Proposed Travelodge Stockley Park

Design Response

This brief report has been prepared to analyse and address the comments made by the Design Officer in relation to the submitted application for the conversion of an existing redundant public house and office space to a Travelodge and Bar Café.

C PROPOSED NORTH ELEVATION
208 1:200@A1

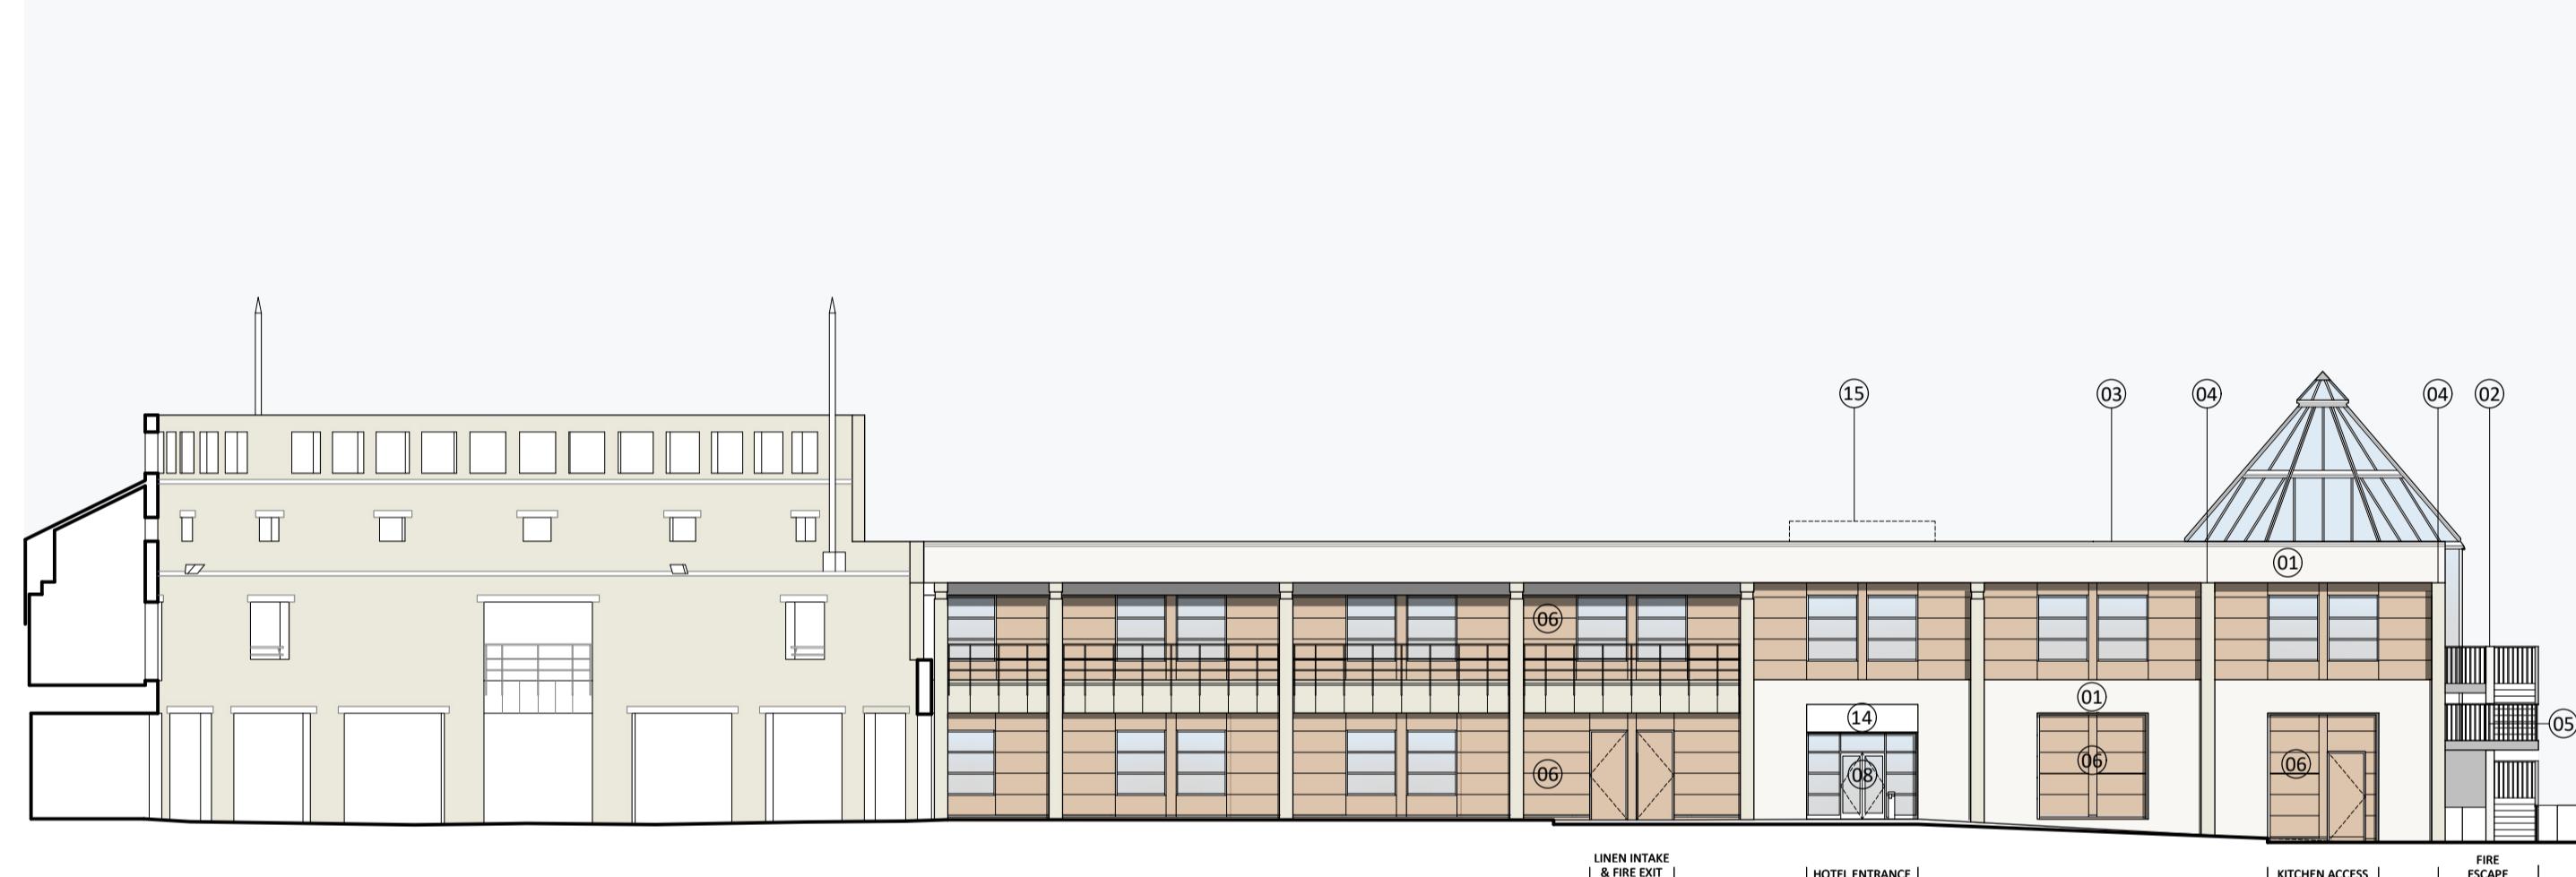
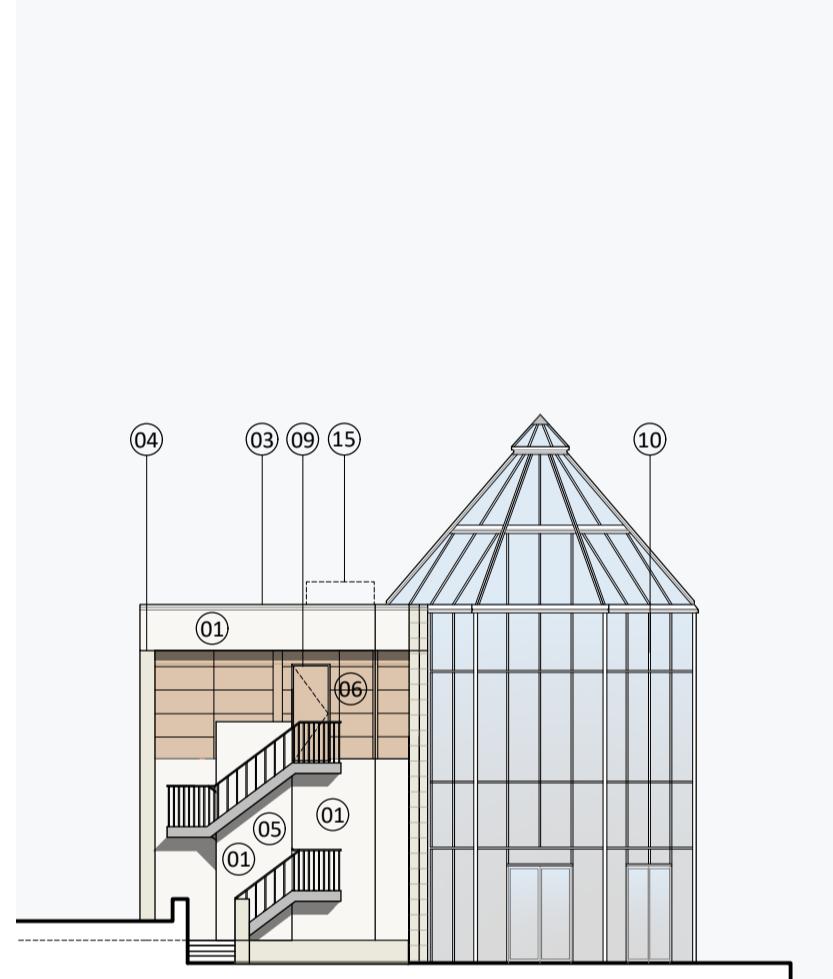
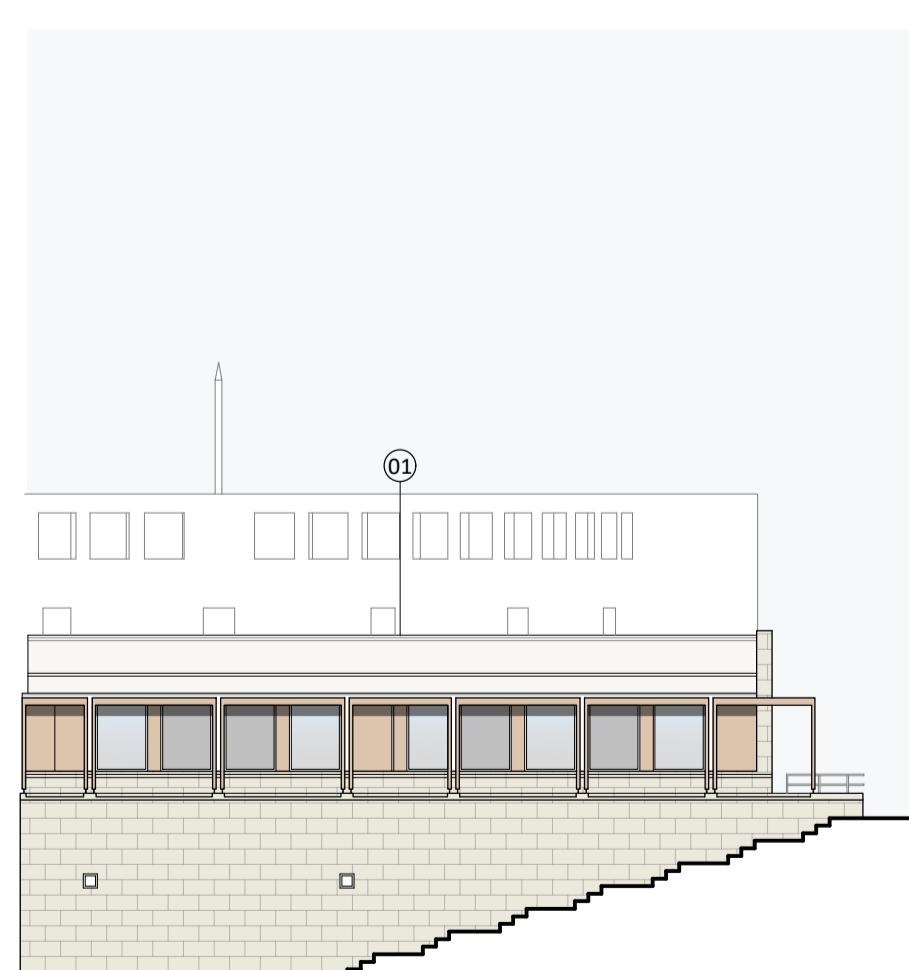
The previous scheme incorporated the new entrance into a rendered element of walling which has now been reduced and the proposed render removed from the palette of materials proposed.

C
208
PROPOSED NORTH ELEVATION
1:200@A1

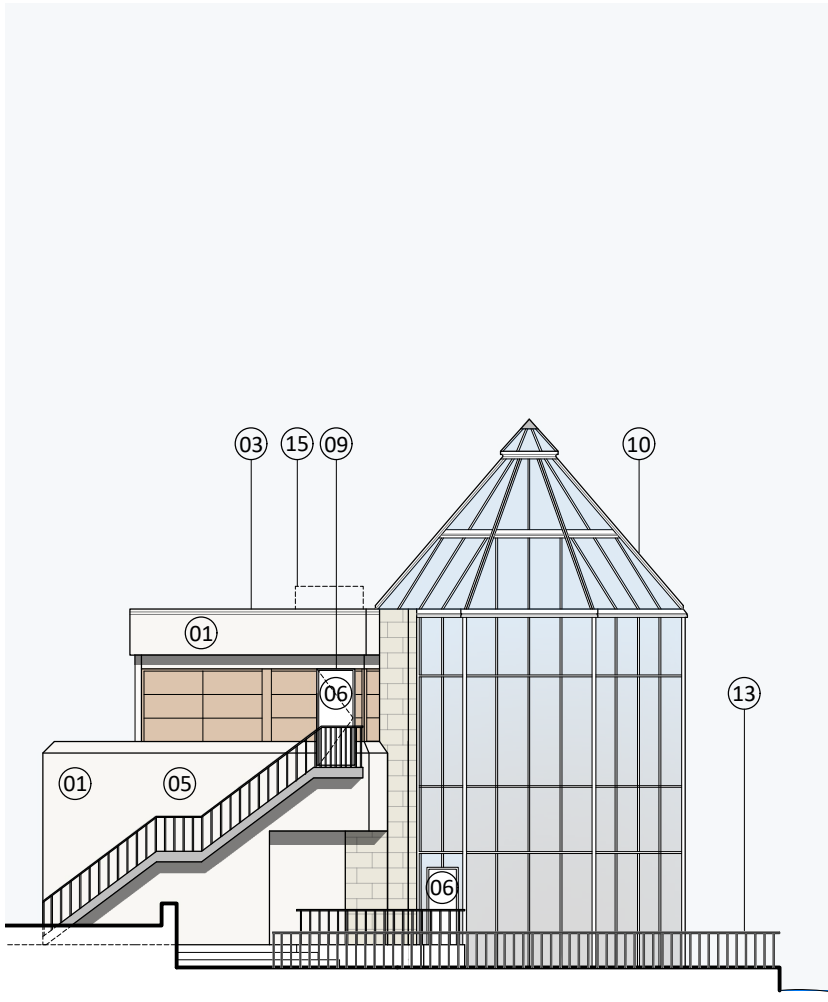
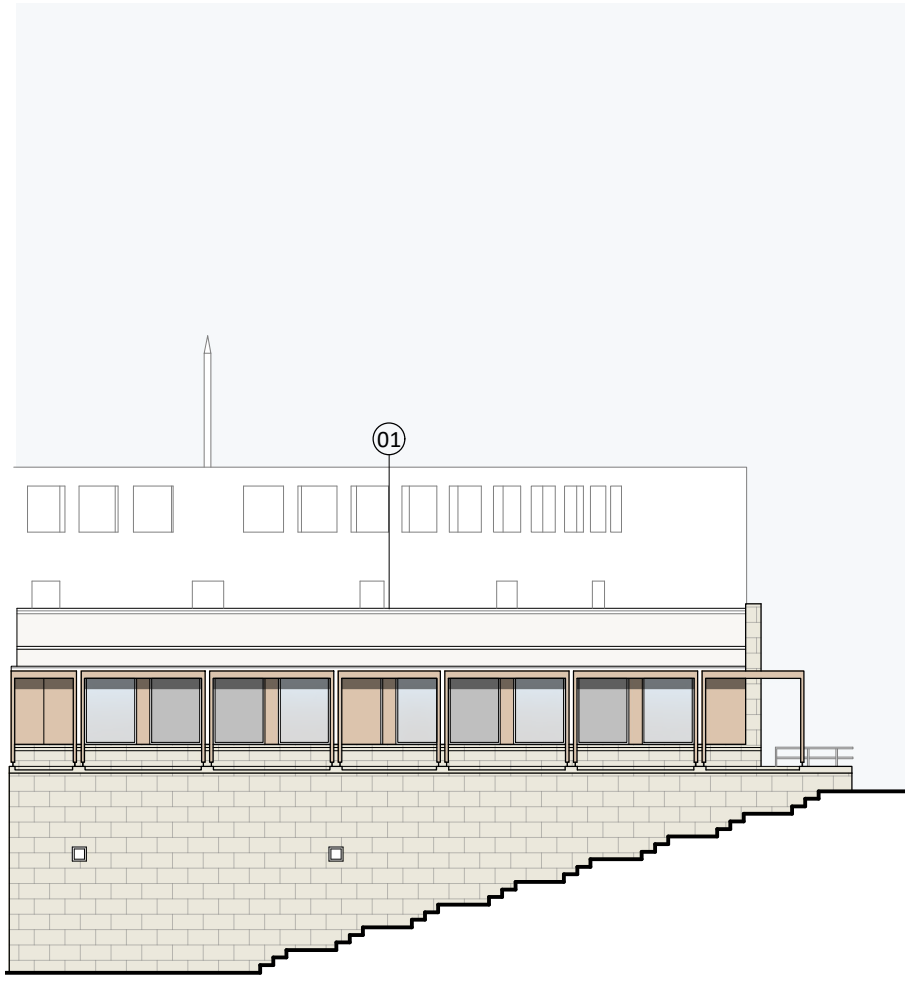
JWA Architects have reviewed the Design Officers comments and have replanned the ground floor and first floor layouts of the proposal to ensure that all 6 of the existing concrete columns on the north elevation are retained and not suppressed into the elevation and thus retaining the strong vertical presence the columns offer. The new wall line will follow the line of the existing wall.

All the existing concrete columns will be cleaned down and emphasized as part of the main feature of the building elevation along with the top horizontal concrete cladding and its associated connection.

On the north elevation the scheme requires the removal of the timber cladding due to the new floor area and the condition of the timber and its flammability.

Due to the restrictions and the new purpose group of the building being of a sleeping risk the requirement for non-combustible cladding is required. We have investigating a number of non-combustible timber effect cladding panels and photos of a sample are attached at the end of this report. The new cladding system will be designed to reflect the existing rhythm of the building elevation. It should be noted that at least half of the existing elevation is glazed with infill panels not all timber
